From: Amanda Scholes on behalf of Planning.Responses
Sent: 12 April 2018 08:44
To: Planning Scanning
Subject: FW: Revised comments re Landscape Planning Consultation on P/1/18/DOC

From: Sue Howell
Sent: 11 April 2018 16:37
To: Simon Davis
Subject: Revised comments re Landscape Planning Consultation on P/1/18/DOC

The proposals now submitted and detailed within Planning Condition 21 drawings 1896-TF-00-00-DR-L-1002 REV PO5, 1896-TF-00-00-DR-L-3002 REV PO4, 1896-TF-00-00-DR-L-3001 REV PO4 have included now improved landscape buffer area with the inclusion of native shrub buffer planting, specimen and feathered trees for screening purposes, plus the retention of wildlife habitat providing reptile translocation zones.

Registered: 05-JAN-18
Site Address: 251 Pagham Road & Land R/O Pagham PO21

drawing title	Landscape General Arrangement (East)				
drawing no.	1896-TF-00-00-DR-L-1002				P03
scale	1:250 @ A1	date	28.09.17	drawn by	AC
				checked by	AC

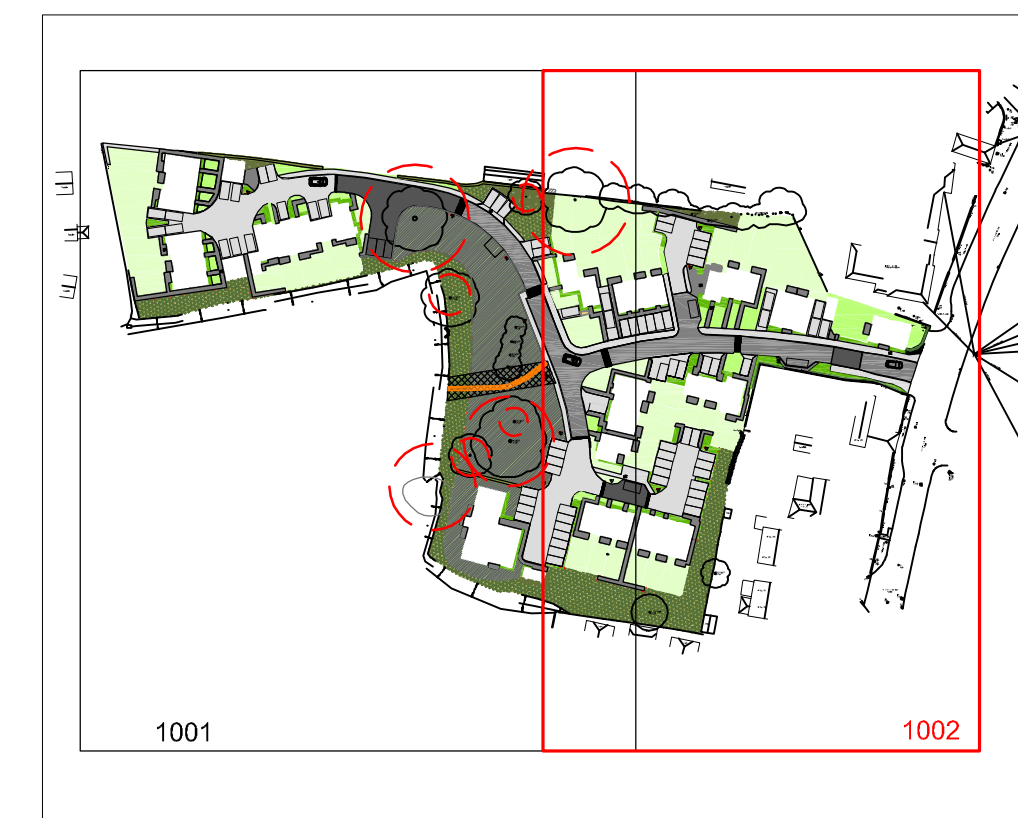
Whilst the DOC application P/1/18/DOC has complied in that it has provided detail of a scheme of landscaping both hard and soft which was the requirement of condition 21, which is adequate in what it is proposing in terms of species type densities and size at time of planting; further reading and agreement with Pagham Parish Council (at the time of application P/25/14/PL) indicates an agreement in principal was to bolster and provide further landscape buffer and reptile translocation zone to the east and south eastern corner of these proposals.

My initial view is that the trees being proposed along the eastern area would be adequate in species choice for this location (to the east) in providing good biodiversity and habitat enhancement without swamping the area and causing future light issues to those properties to the east. The understory here is shown to be wildflower EM4 which would also be suitable and in consideration of habitat, however the ground cover planting shown to the edge of the carpark is ornamental in nature and will not provide a screening buffer. **I conclude that if the agreement in principal as appears to be, was for enhancement in width and height of landscape buffer to the rear of Pagham Road dwellings then this has not been achieved and therefore I would retract my recommendation for discharge of condition 21 because of this reason and request that further appropriate buffer screening to be proposed in this area.**

“The Structural Planting along the east boundary is completely inadequate as requested by the Parish Council and individual objections to P/125/14/PL. Proper screening of development is required not token planting”

Further to my reassessed comments made below (22/03/2018) Greenspace has been in consultation with Terra Firma the Landscape Architects acting on this development. Having discussed the proposals for the DOC application at that time and investigated the agreement in principal for additional landscape buffer to the rear of the adjoining Pagham Road properties, the applicants have now revised their proposal to accommodate this position.

From the revised detail submitted in the drawings above, I am confident that the developer has now complied with the Condition 21 requirements, the agreement in principal re buffer and the detail imposed under application P/25/14/PL I can confirm that therefore I would **recommend the discharge of Condition 21 Landscaping reserved under planning approval P/125/14/PL on this application P/1/18/DOC.**
